Rezoning Transportation Analysis

Petition Number: 2021-092

Date	Description
06-01-2021	First Review (KP)

SHEET NUMBER
RZ-1.1

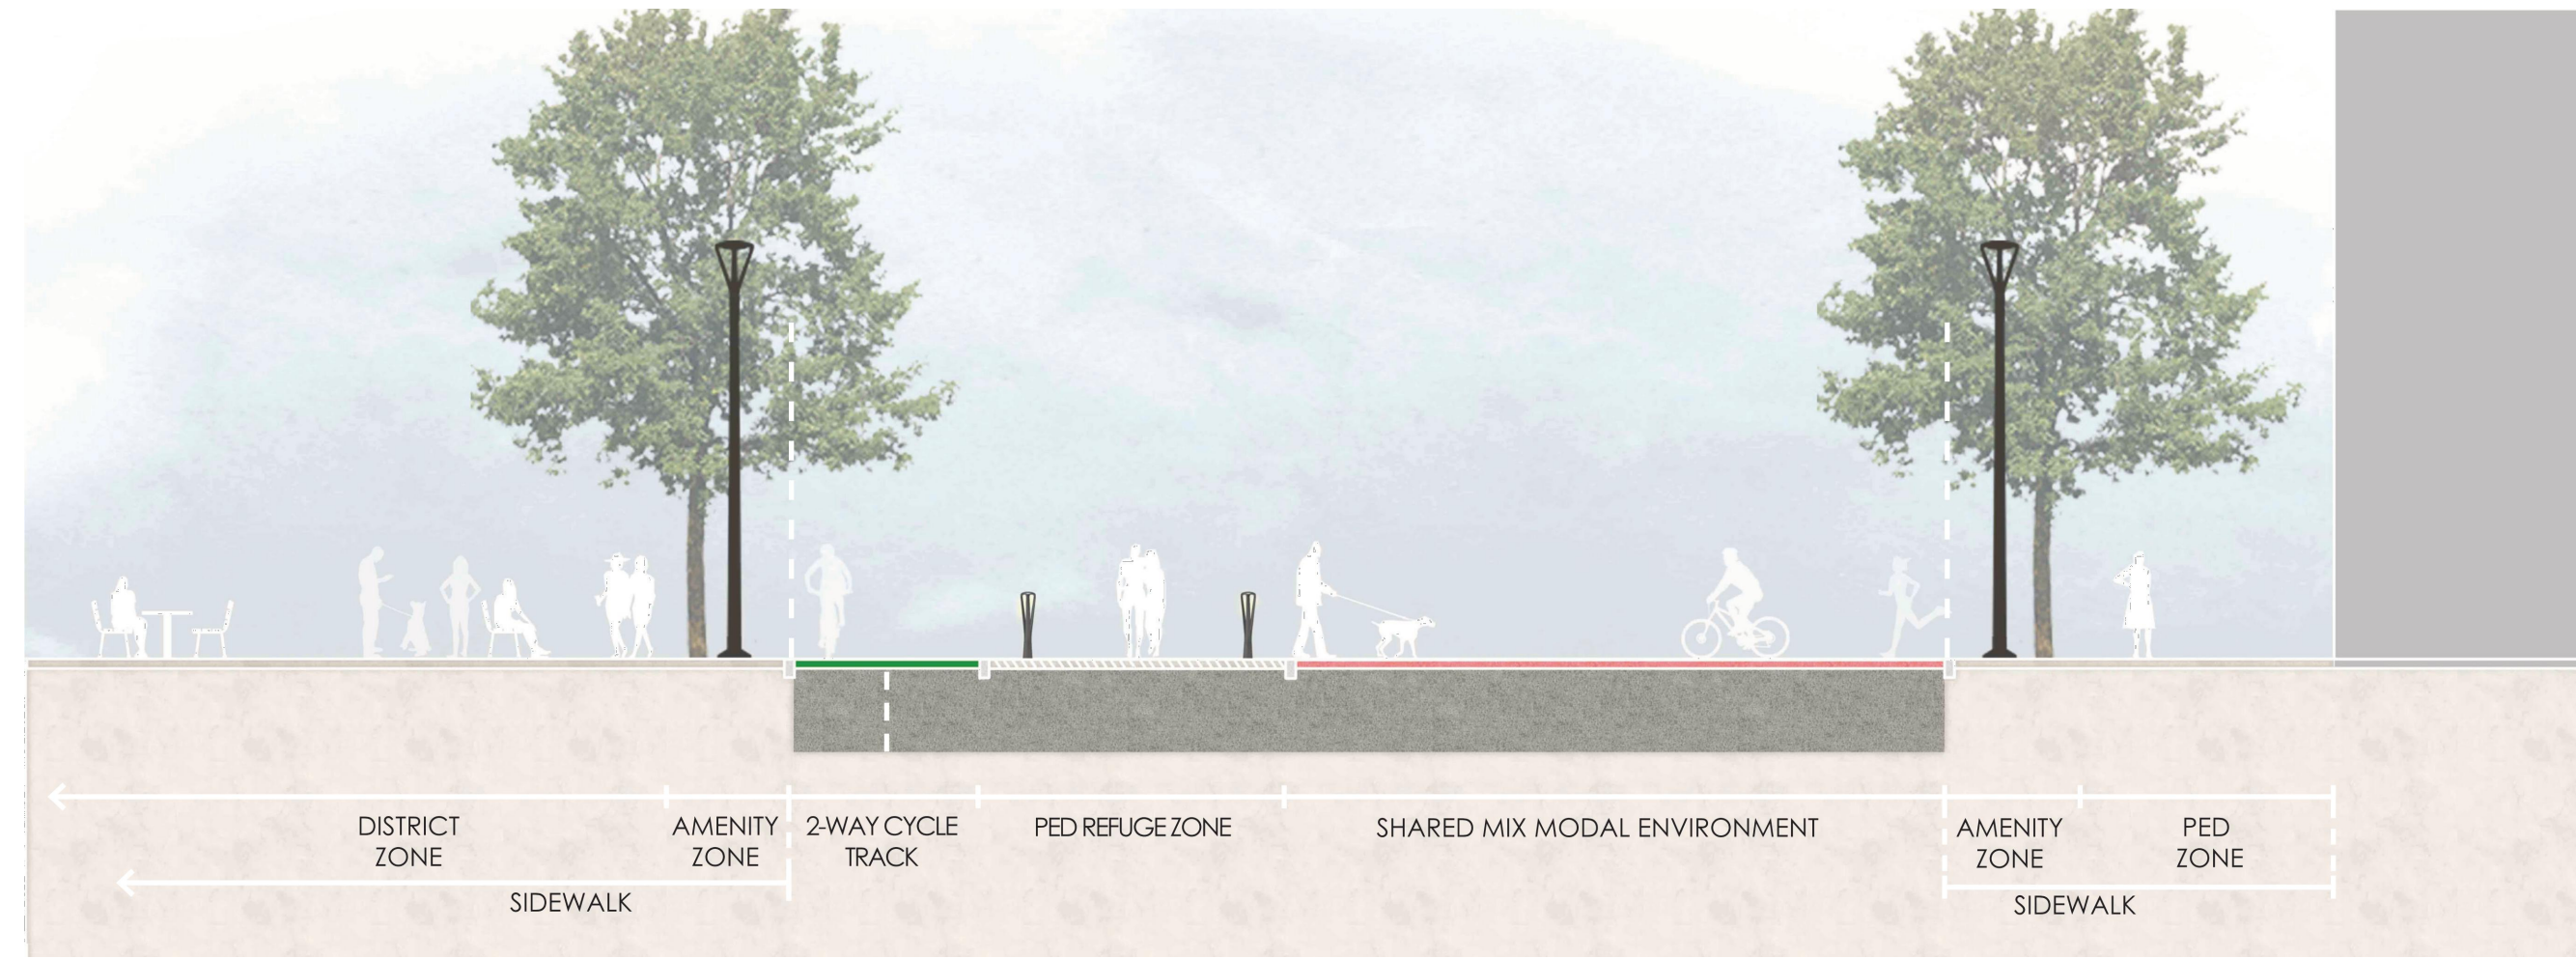
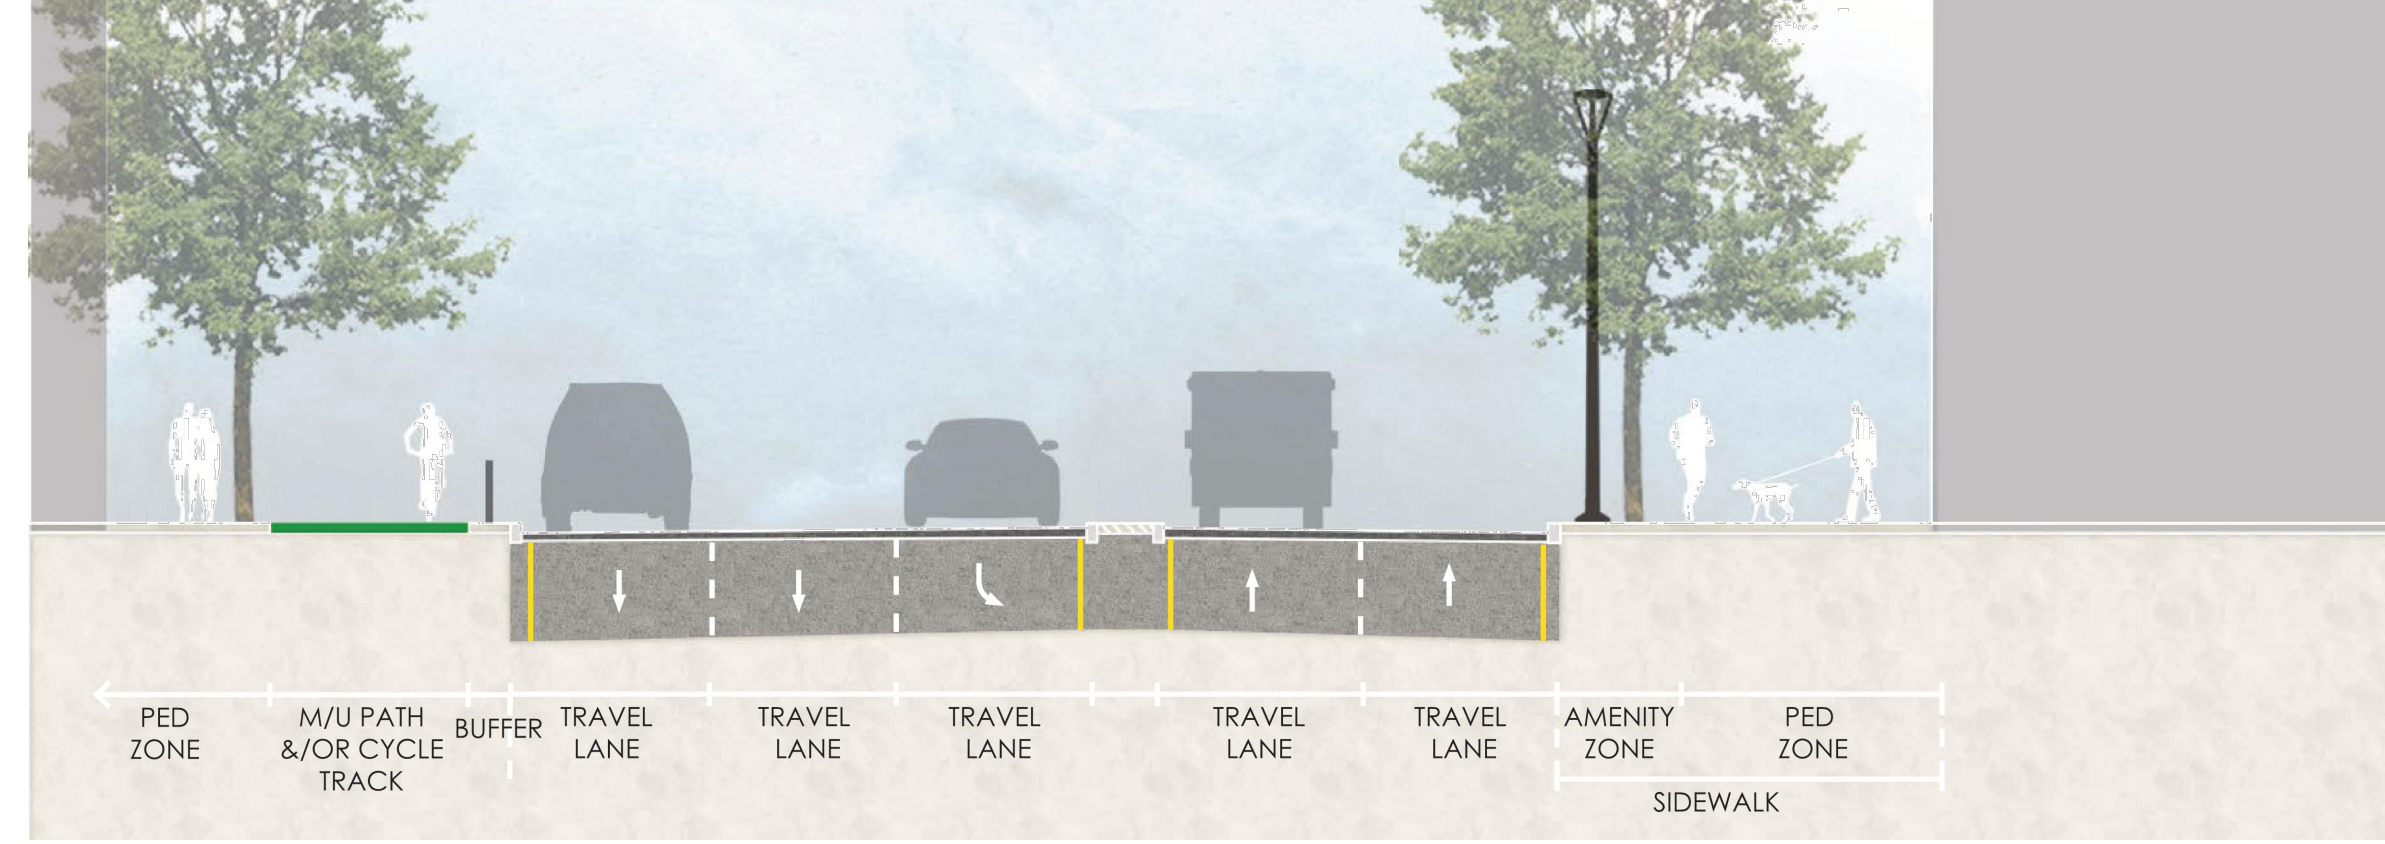
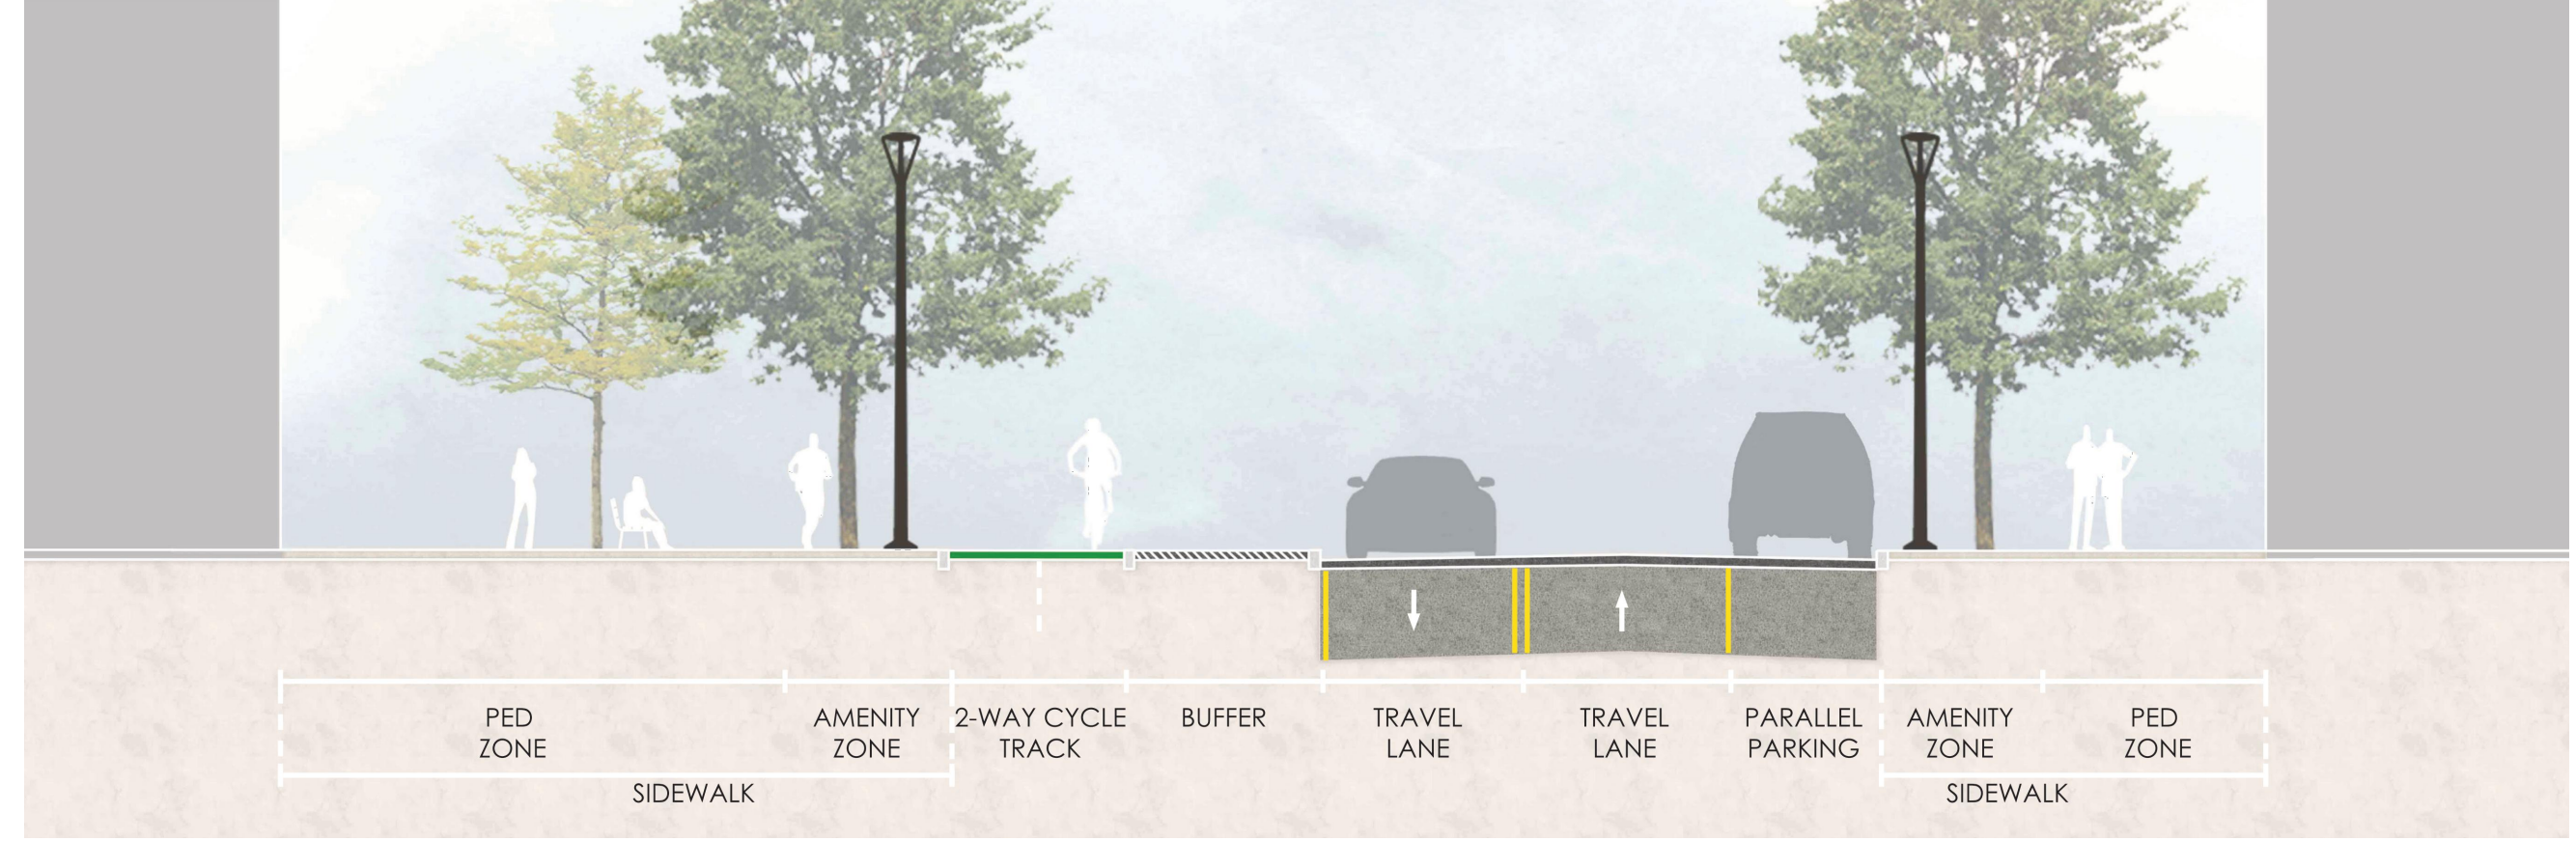
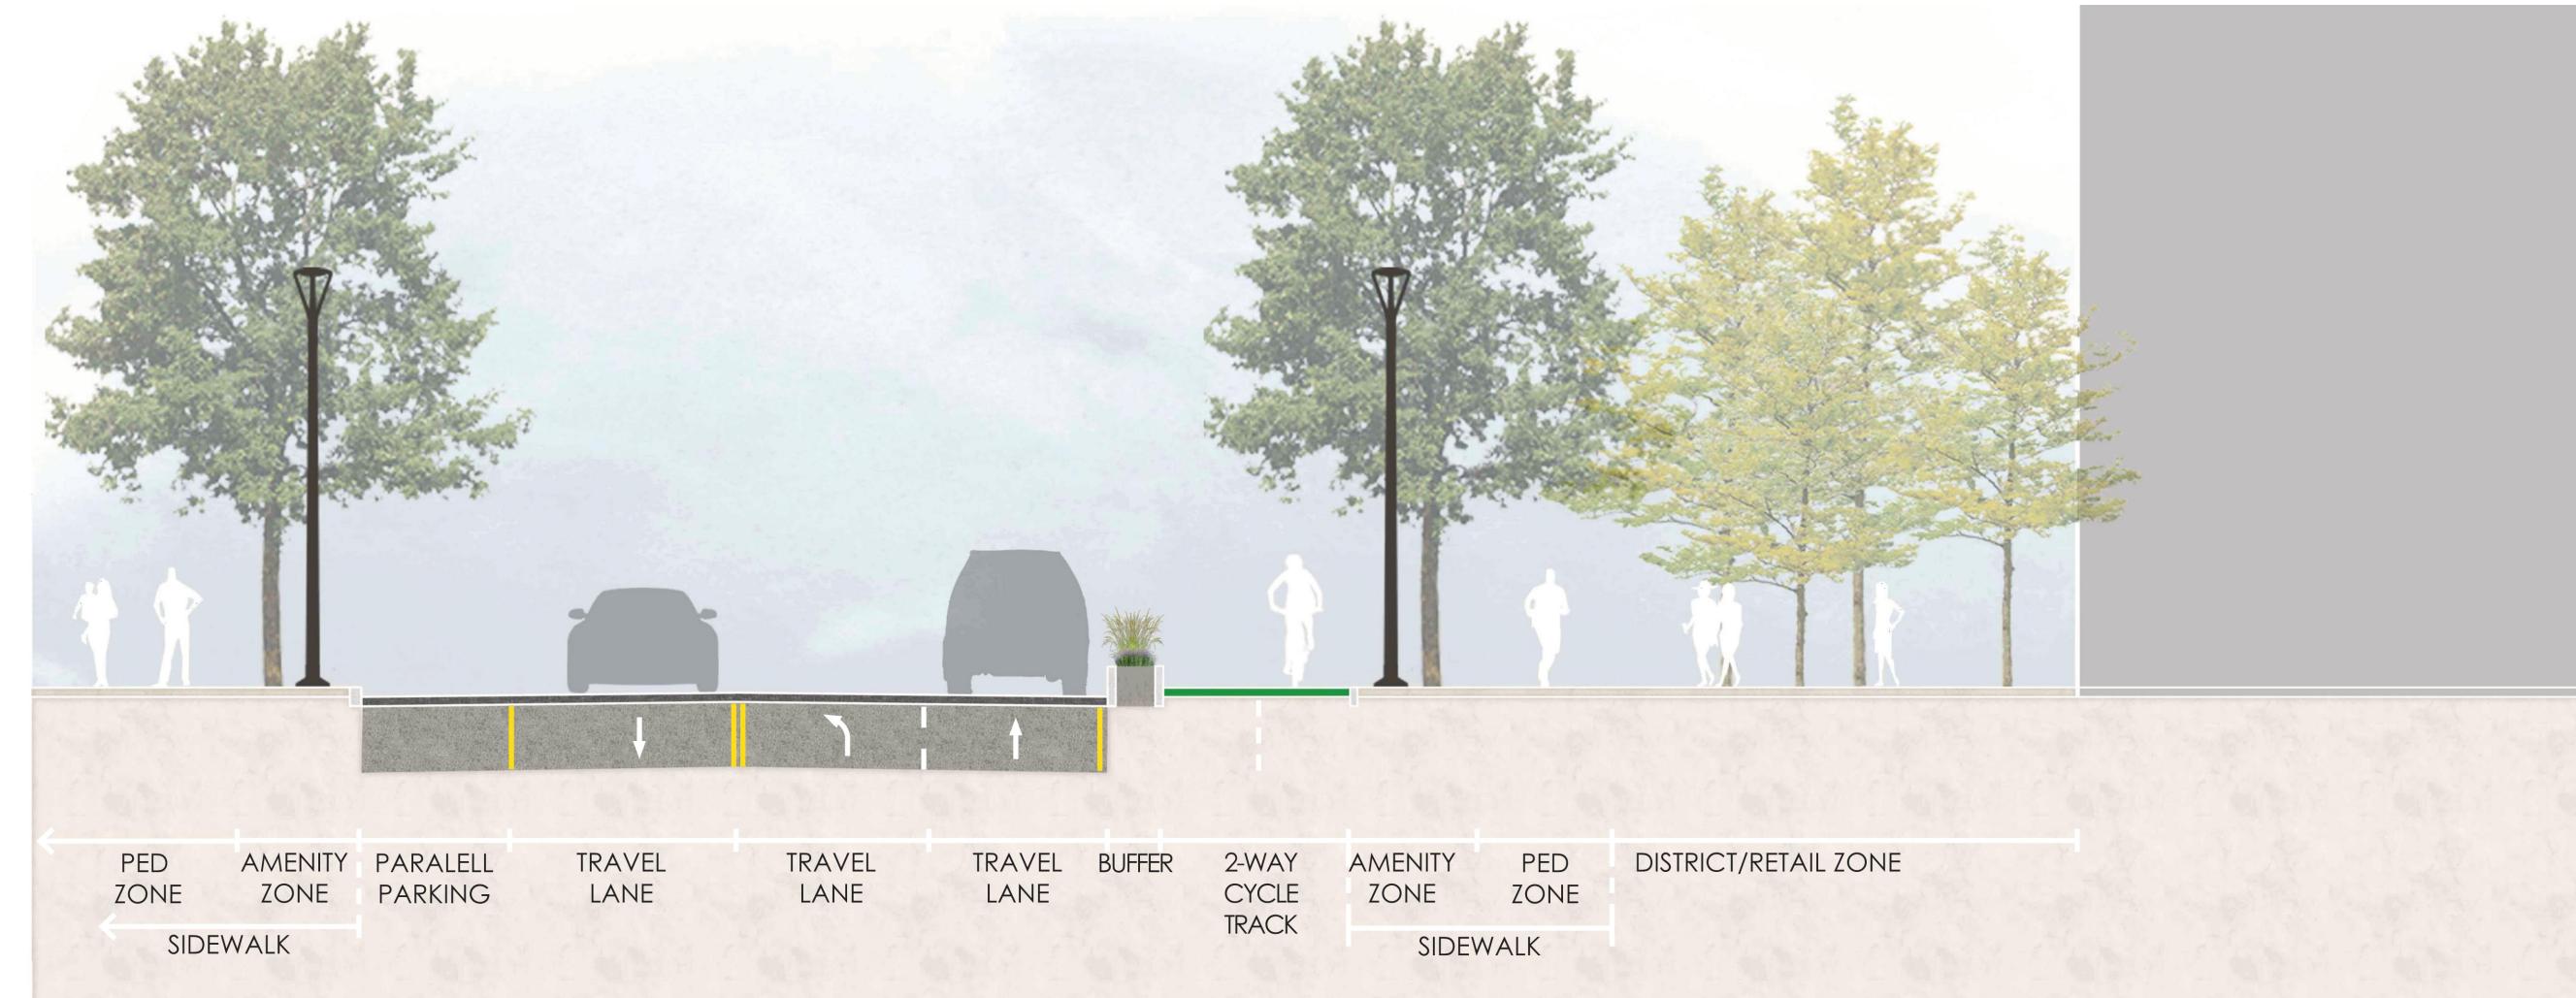
1. **Curb line:** The proposed zoning district has a setback measured from back of the existing or proposed future curb line. Revise Sheet RZ-1.1 by adding the curb line dimensions to the cross sections provided. Please note: The following curb line dimensions proposed are conceptual and may be altered as coordination with CDOT throughout the rezoning process ensues.

- a. **Morehead Street:** The location of curb and gutter will be moved and located 38-feet from the existing centerline to the back-of-curb.
 - b. **McDowell Street:** The future location of curb and gutter is in the existing location.

- c. **Baxter Street (Section C-C)** – The location of curb and gutter will be moved and located to 21.5-feet from the existing centerline to each back-of-curb.

- d. **Baxter Street (Section D-D)** – The location of curb and gutter will be moved and located to 19-feet from the existing centerline to each back-of-curb.

- e. **Baxter Street Extension (Section E-E)** – The location of curb and gutter will be moved and located to 21.5-feet from the existing centerline to each back-of-curb.

- f. **Proposed Public Street (Section F-F)** - The location of curb and gutter will be located 18.5-feet from the proposed centerline to each back-of-curb.

3. **Right-of-way and Other Infrastructure Dimensions:** Revise Rezoning Sheet RZ-1.1 to include detailed dimensions for each infrastructure item, and the total right-of-way for the cross sections shown. Refer to the USDG Cross sections and on-street parking details, located within the Charlotte Land Development Standards Manual, to determine the appropriate widths associated with each infrastructure item and the cross sections' total widths. Revise the site plan sheets by clearly labeling each public and private street section as well as each access point. Labeling each street section and access point will allow for thorough comments throughout the rezoning and permitting process. CDOT prefers the separated cycle track and sidewalk for McDowell Street (cross-sections A-A and B-B). Please note: The following right-of-way dimensions proposed are conceptual and may be altered as coordination with CDOT throughout the rezoning process ensues.

- a. **Morehead Street:** 56-feet of right-of-way dedication measured from the existing road centerline.
 - b. **McDowell Street:** 110-feet of total right-of-way dedication, 55-feet measured from the existing road centerline to each right-of-way line.

- c. **Baxter Street (Section C-C)** – 93-feet of total right-of-way dedication, 46.5-feet measured from the existing road centerline to each right-of-way line.

- d. **Baxter Street (Section D-D)** – 86-feet of total right-of-way dedication, 43-feet measured from the existing road centerline to each right-of-way line.

- e. **Baxter Street Extension (Section E-E)** – 93-feet of total right-of-way dedication, 46.5-feet measured from the existing road centerline to each right-of-way line.

- f. **Proposed Public Street (Section F-F)** - 73-feet of total right-of-way dedication, 36.5-feet measured from the existing road centerline to each right-of-way line.

4. Revise the Rezoning Sheet RZ-1.0 and RZ-1.1 by establishing a cross section associated with the proposed private street connecting McDowell Street to Baxter Street Extension. Include the cross section on Rezoning Sheet RZ-1.1.
